CITY OF ALBUQUERQUE

**Re: Floor and Decor
Erosion and Sediment Control Plan
Engineer's Stamp Date 9-5-17 (F17E032)**

Based upon the information provided in your submittal received 9-5-17, the above referenced plan is not approved to be included in the SWPPP or to apply for an ESC Permit for grading and Building Permit until the following comments are addressed:

EROSION AND SEDIMENT CONTROL PLAN

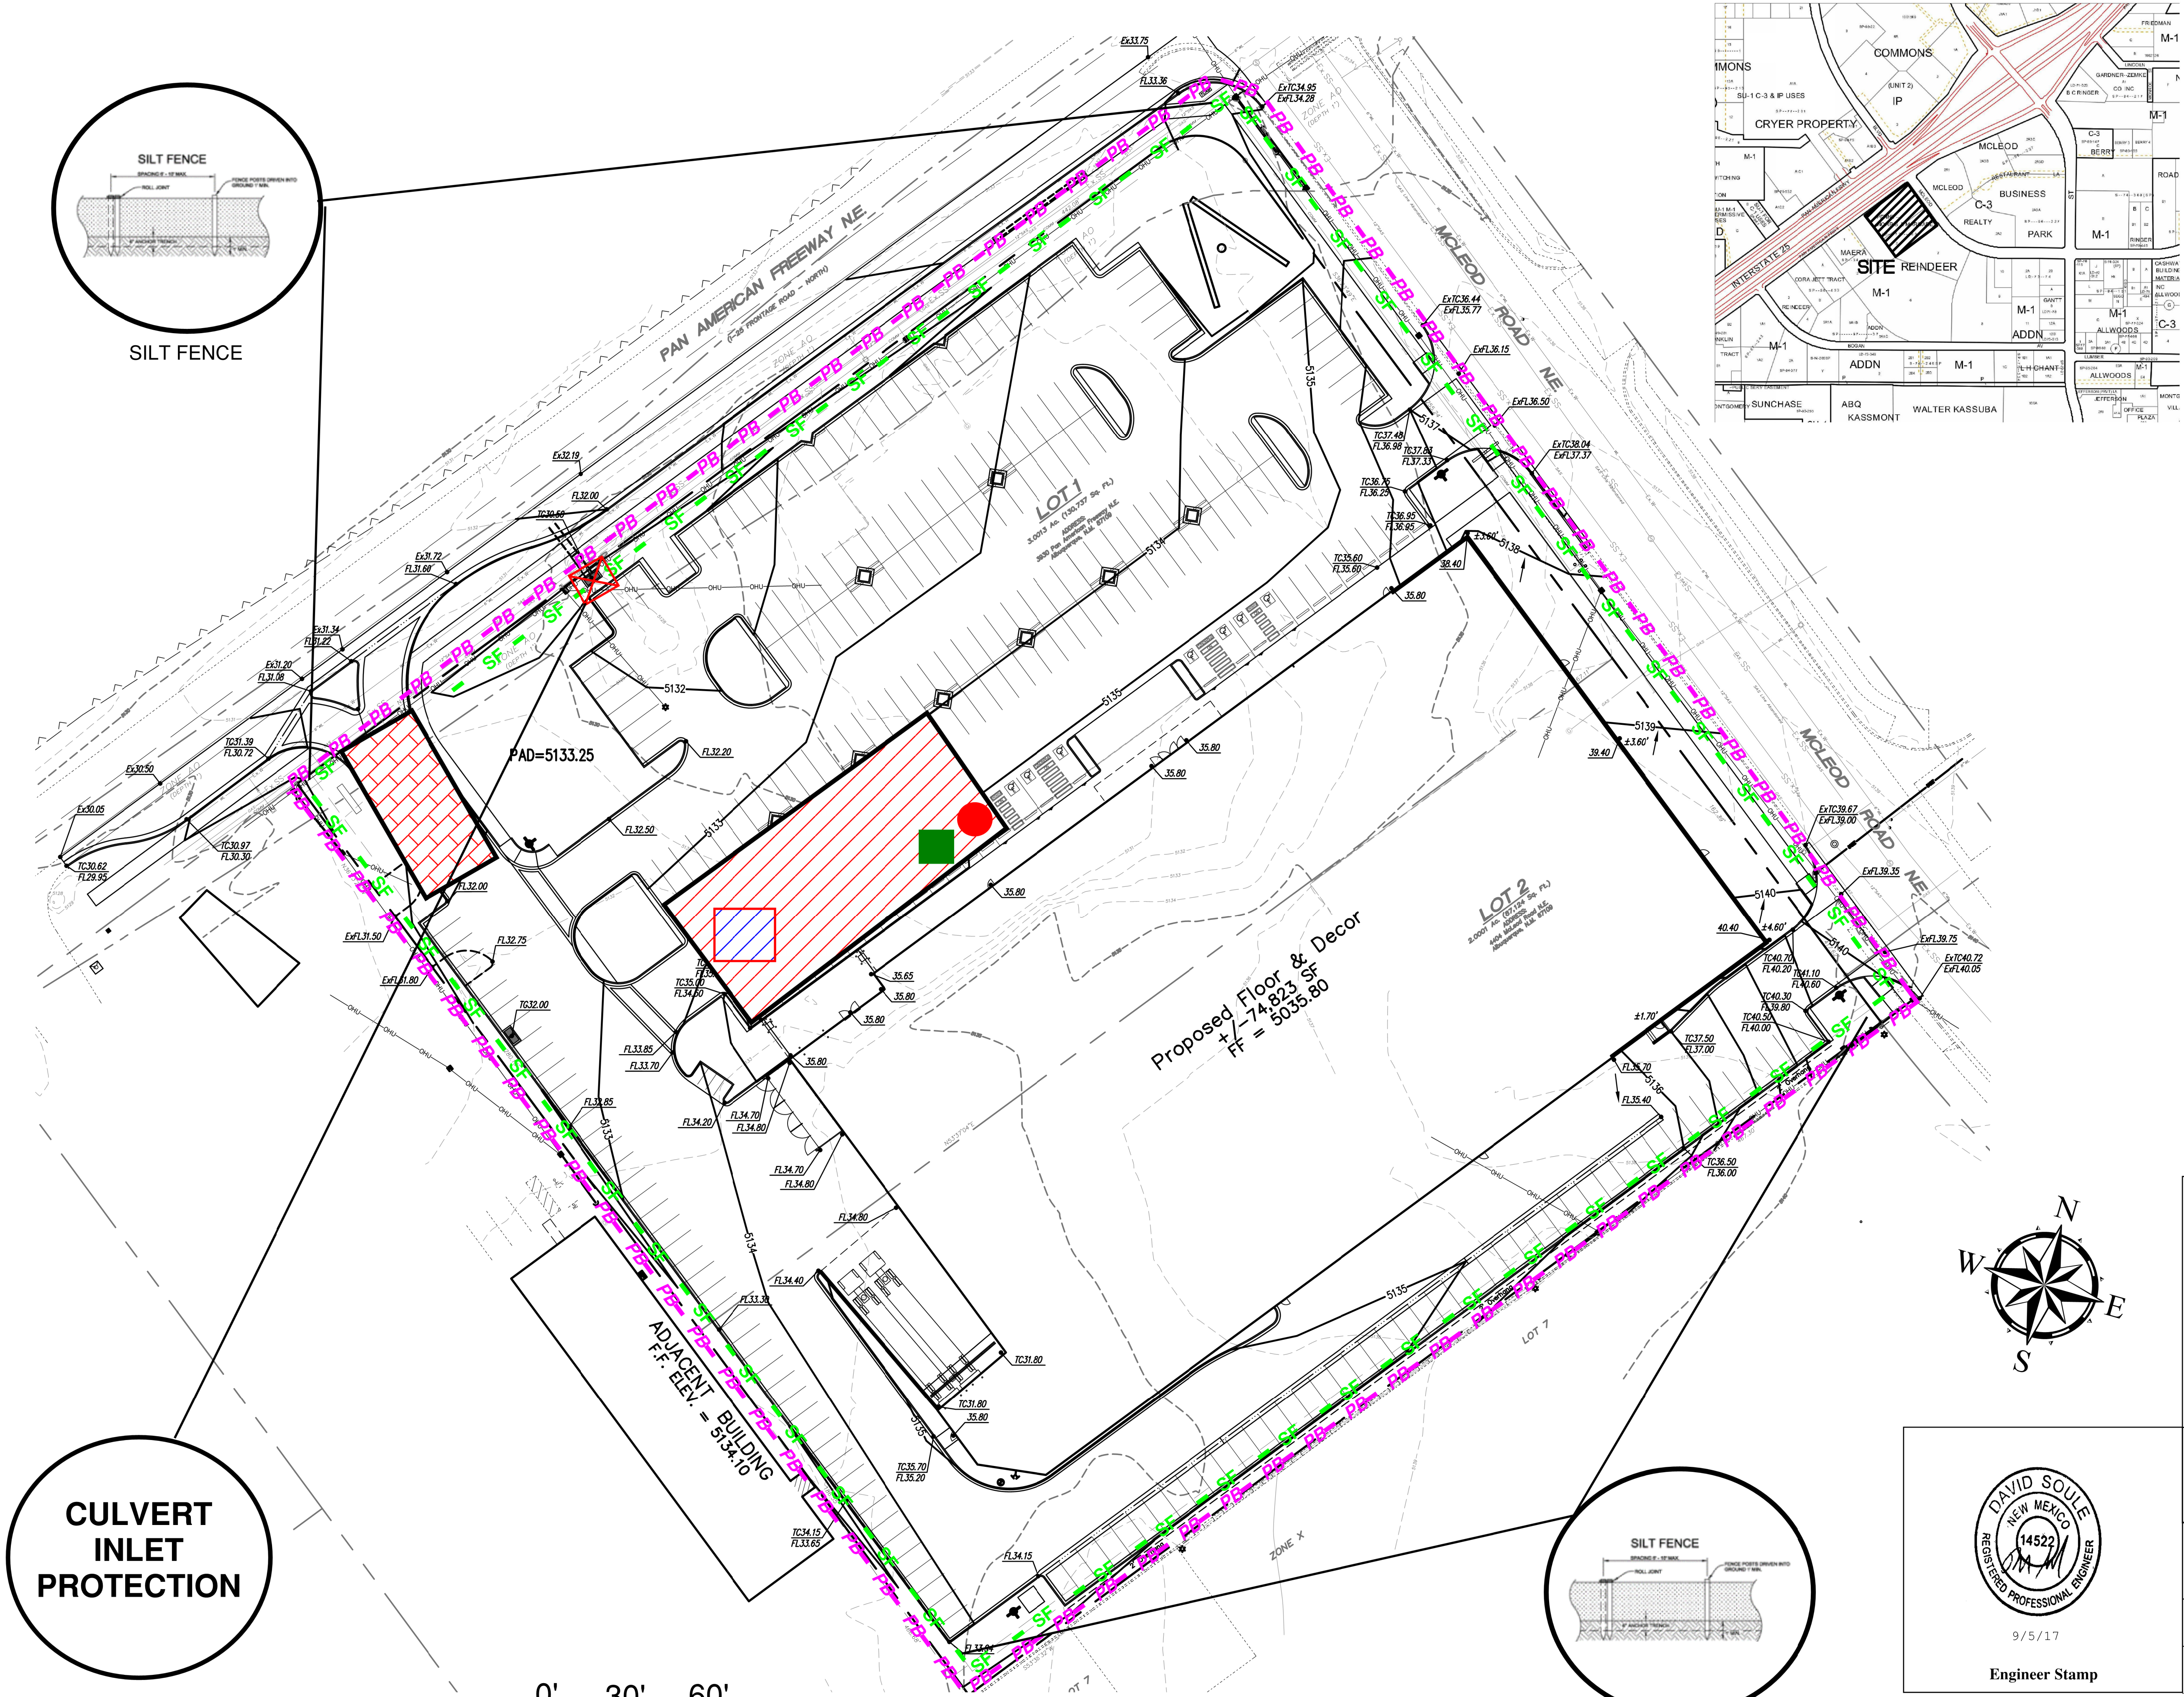
1. The track-out pad should be relocated from the low-point of the site to McLeod Rd.
2. The site is approximately 4 acres. Provide a sediment pond(s).
3. Provide inlet protection for the inlet near the west corner (TG 32.00) and for the possible trench drain south of the building if the trench drain is connected to the onsite storm drain.
